**BP#2016-01901 49 Hancock Street**

Please review the attached revision per your comments.

Summary:

REVISIONS	
1	-3/29/16
2	-7/11/16
3	-
4	-
5	-

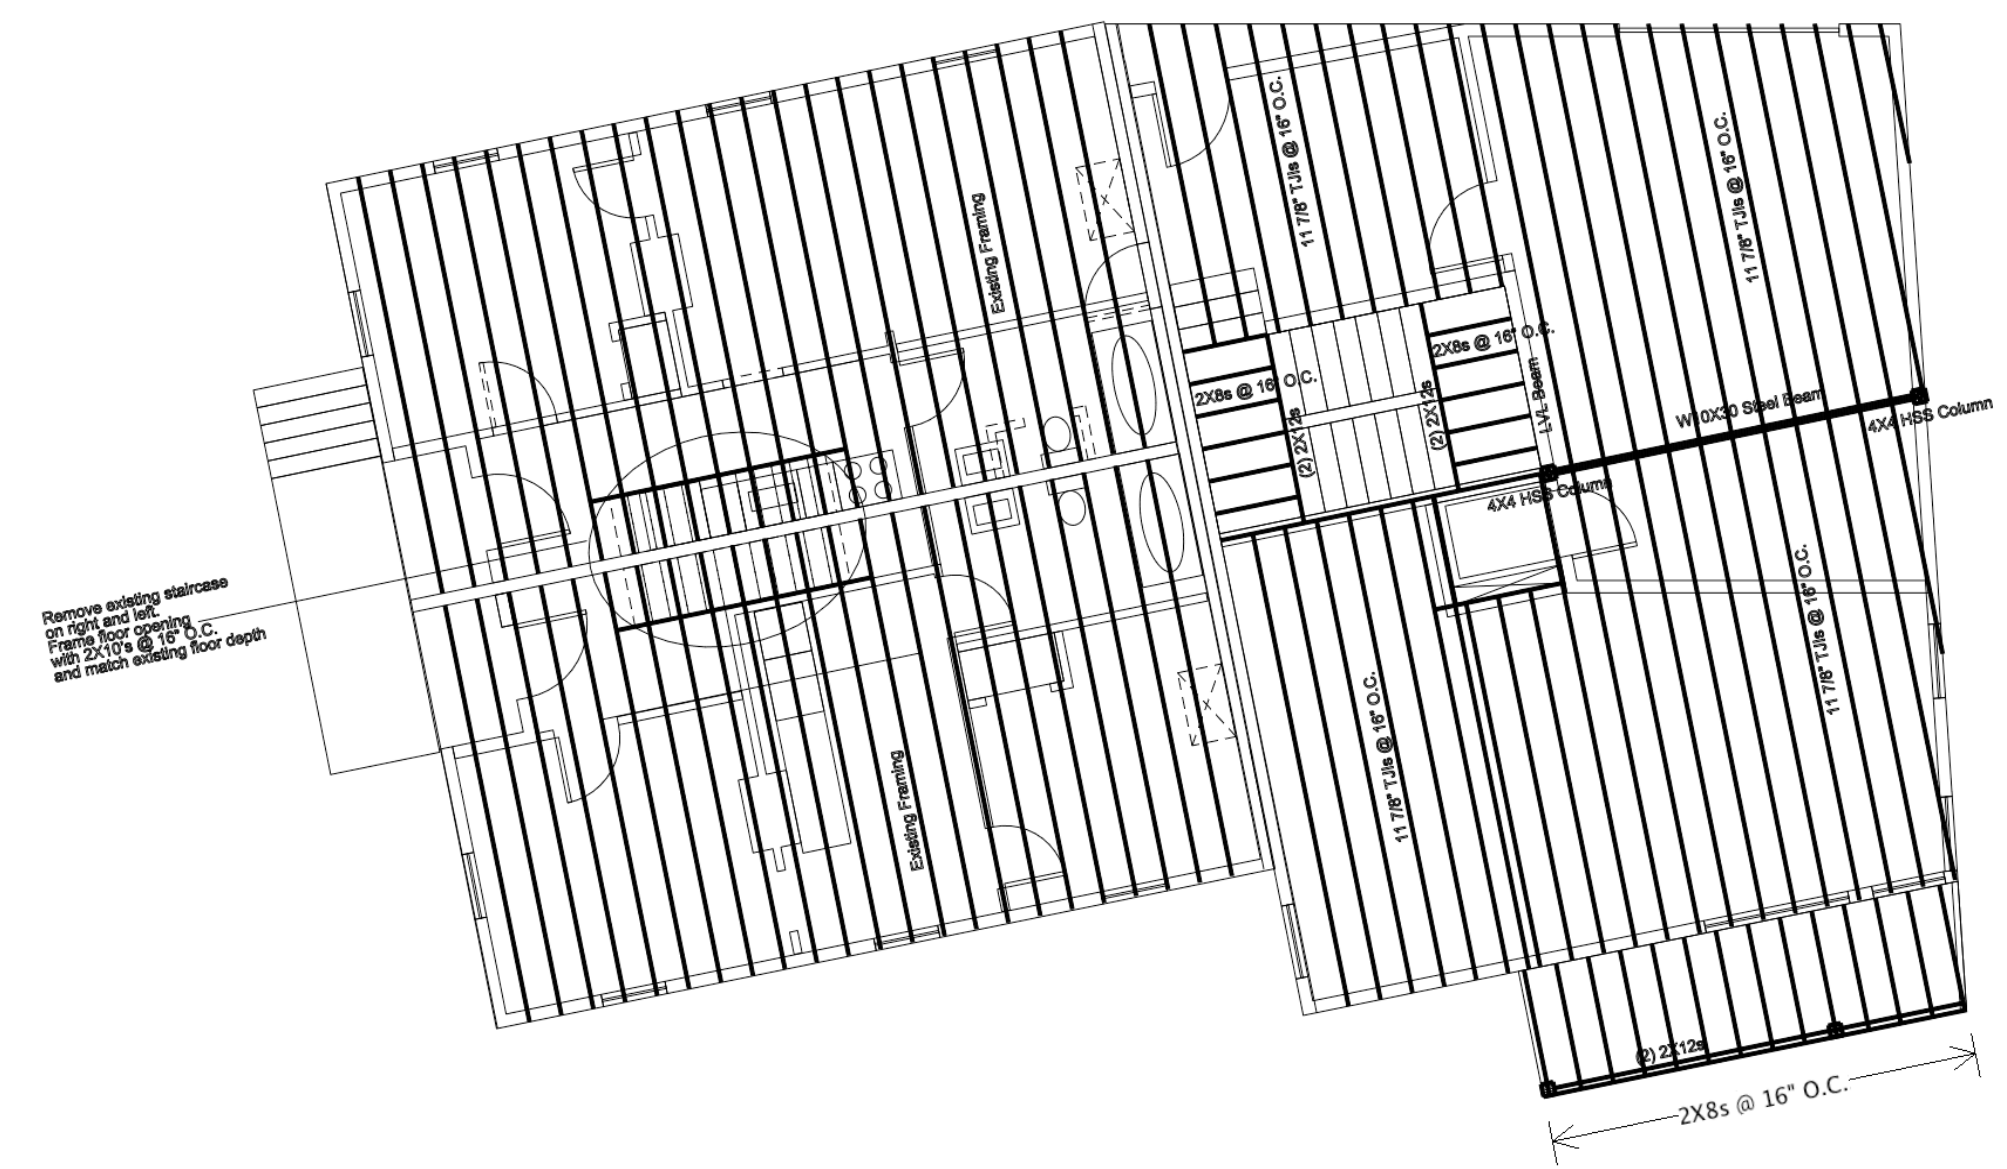
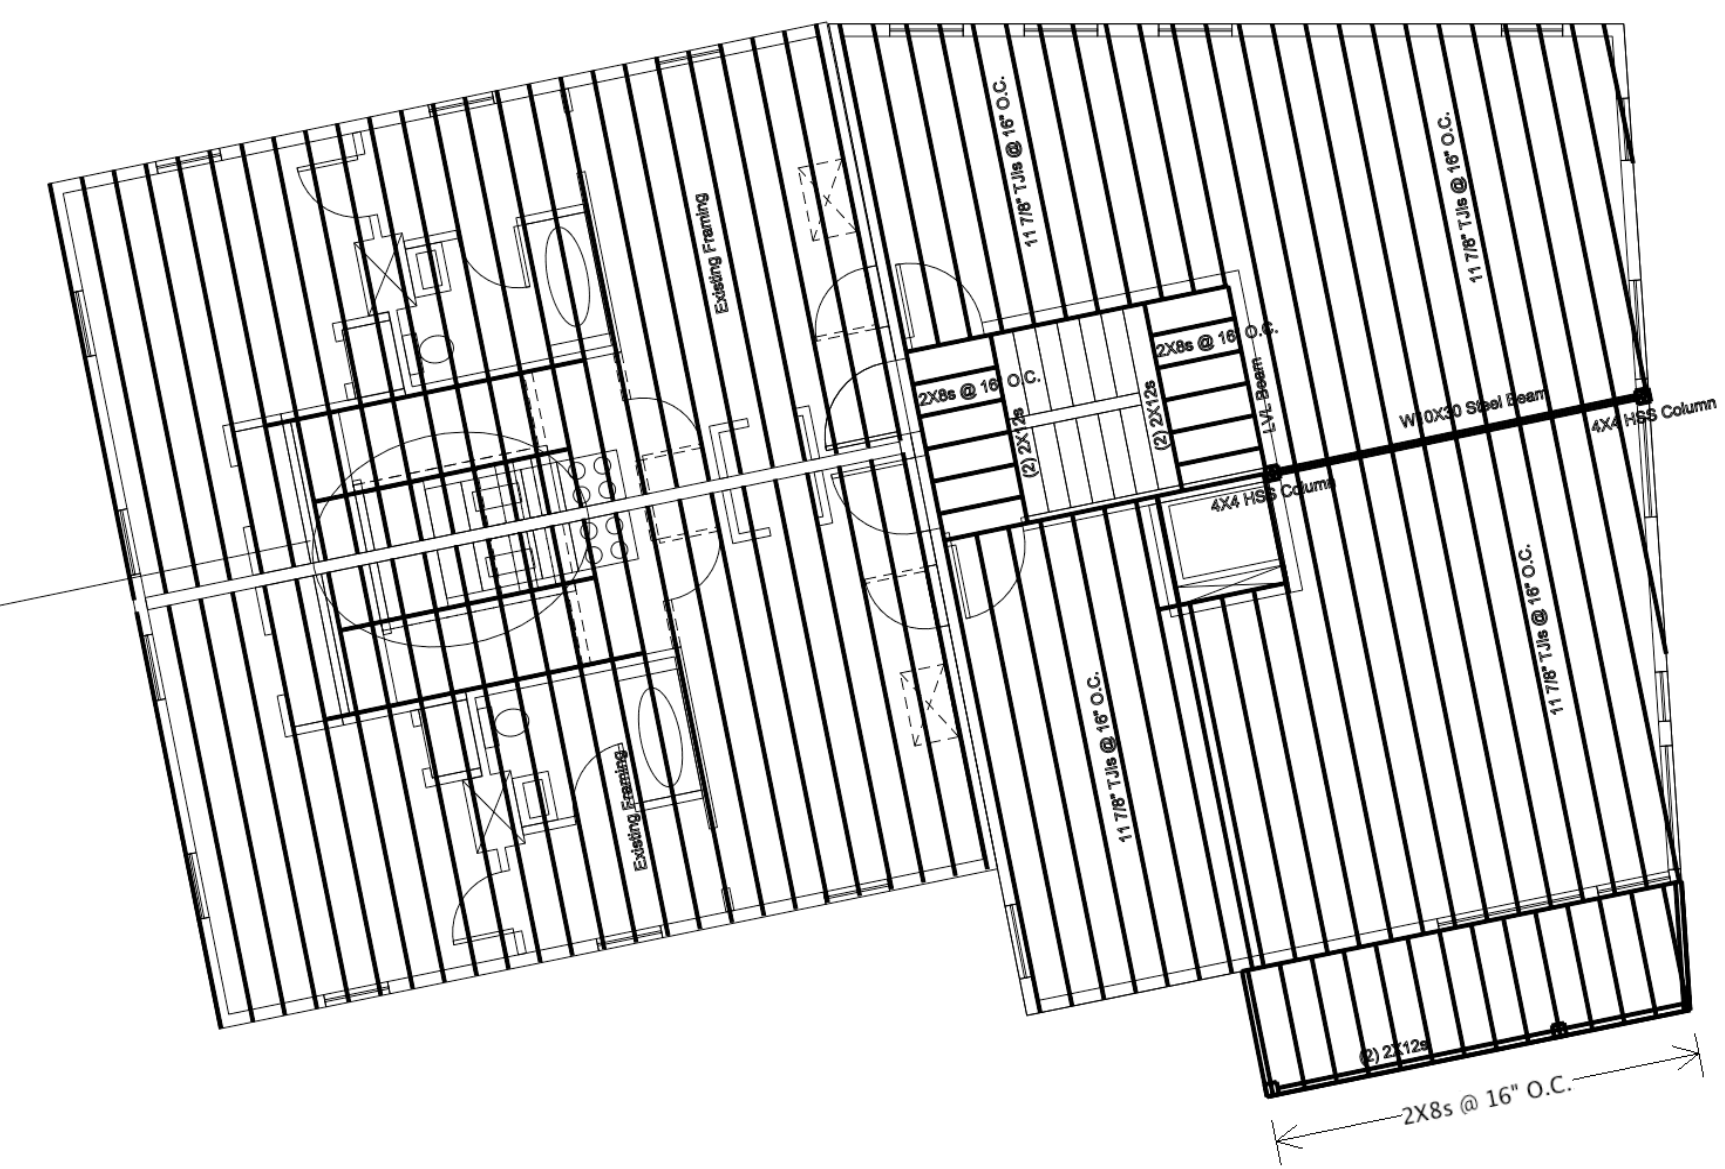
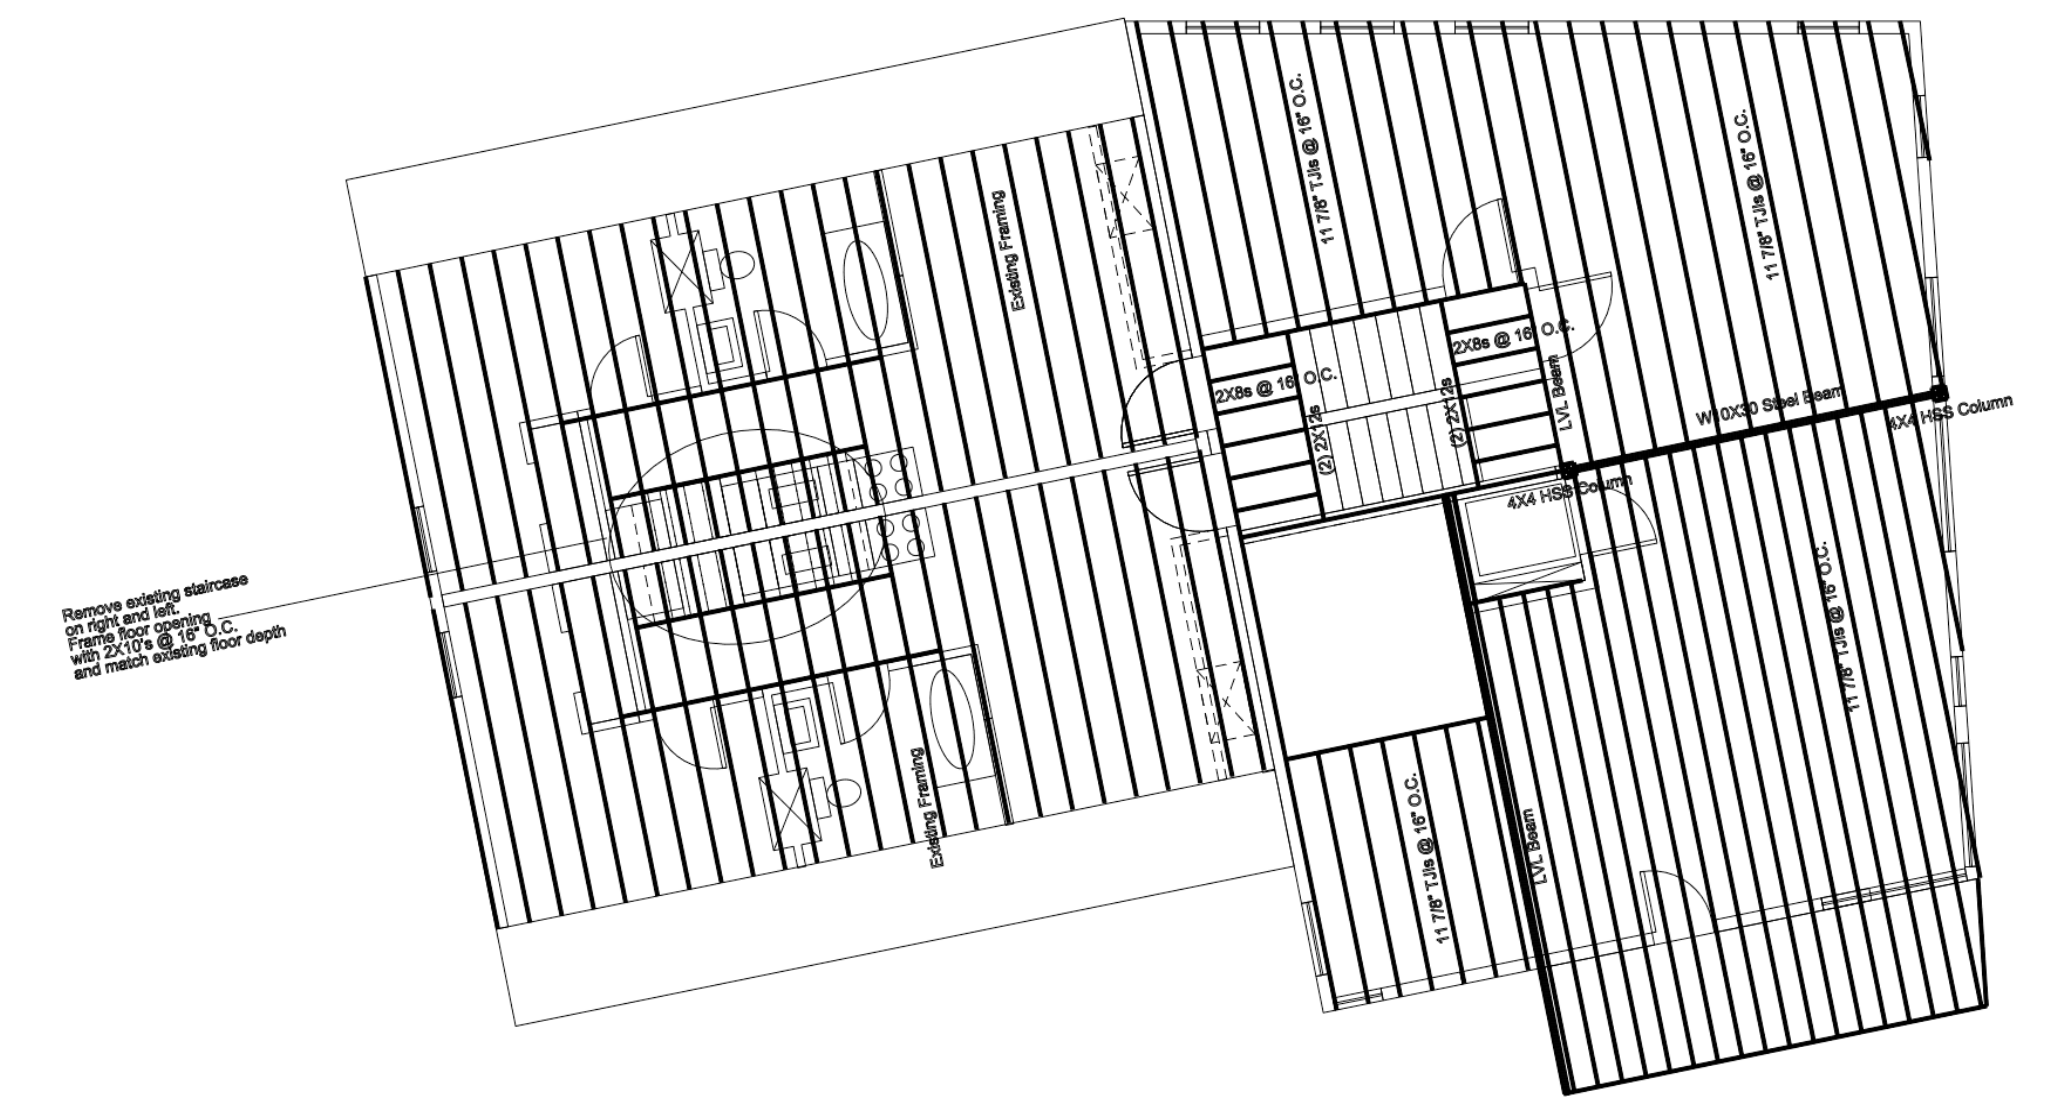
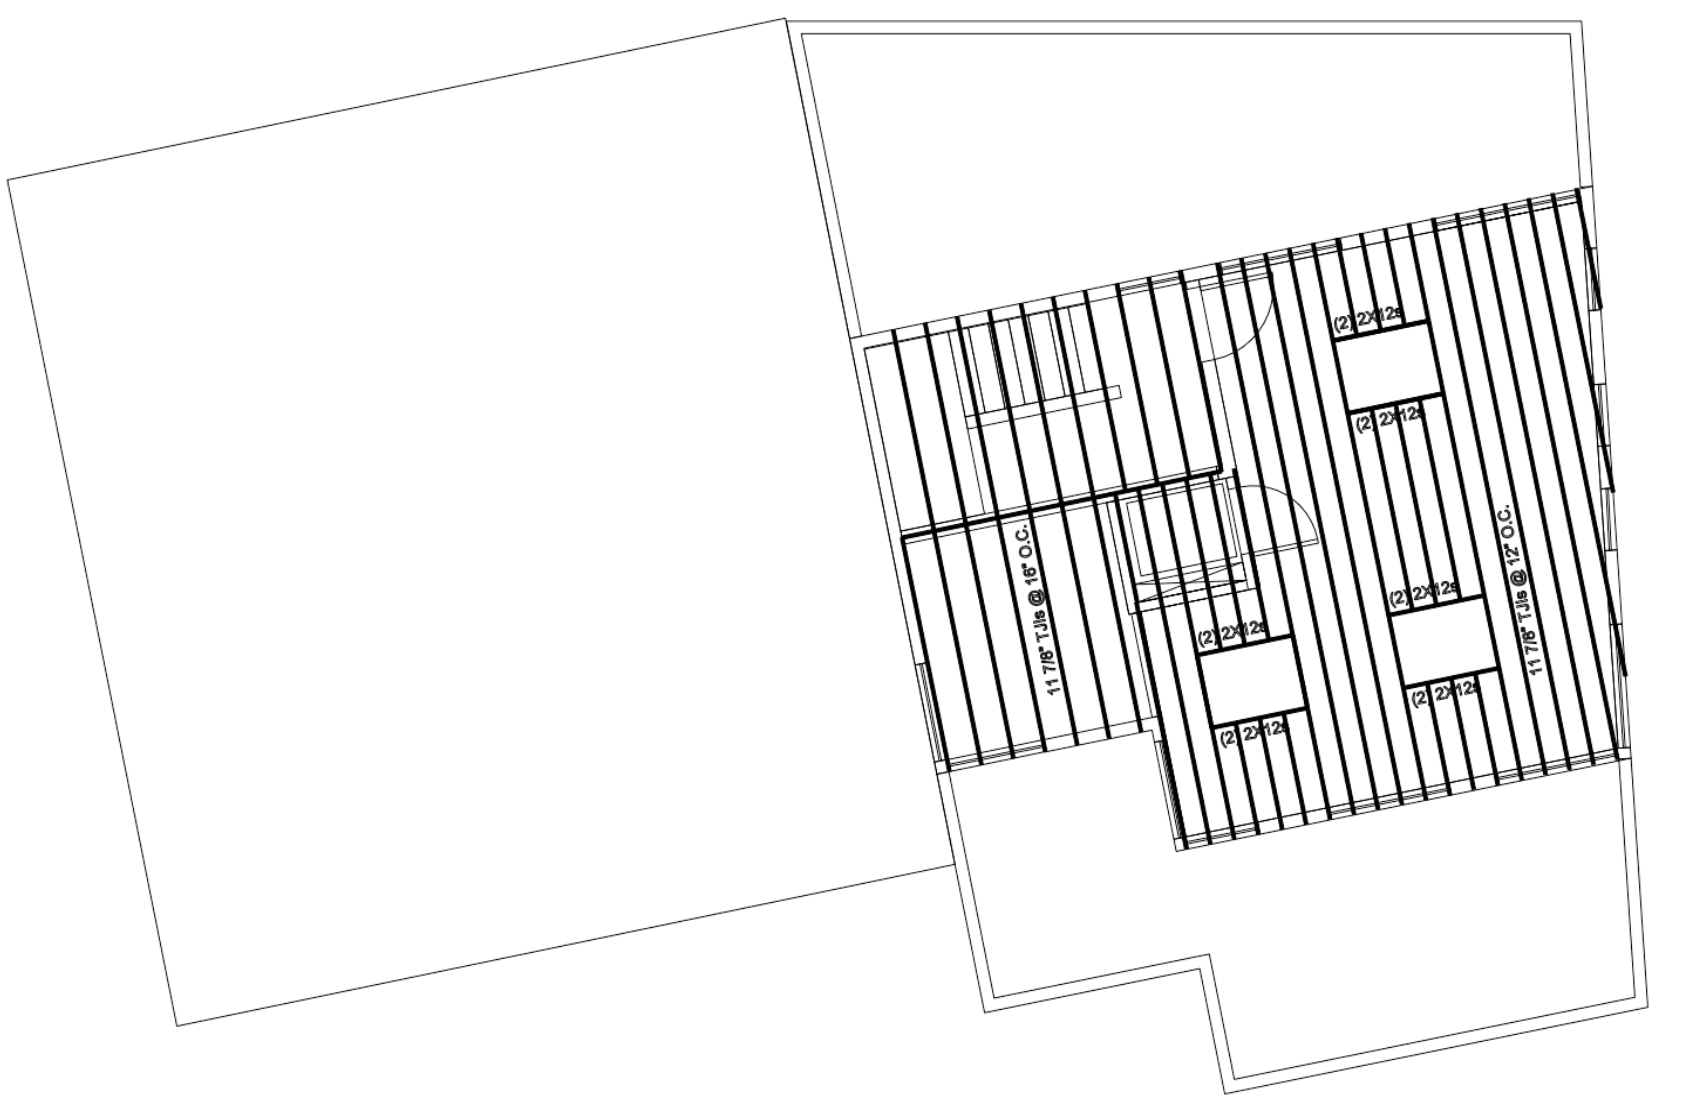
8. S1.1 Foundation added for deck posts. Deck posts to be steel posts.
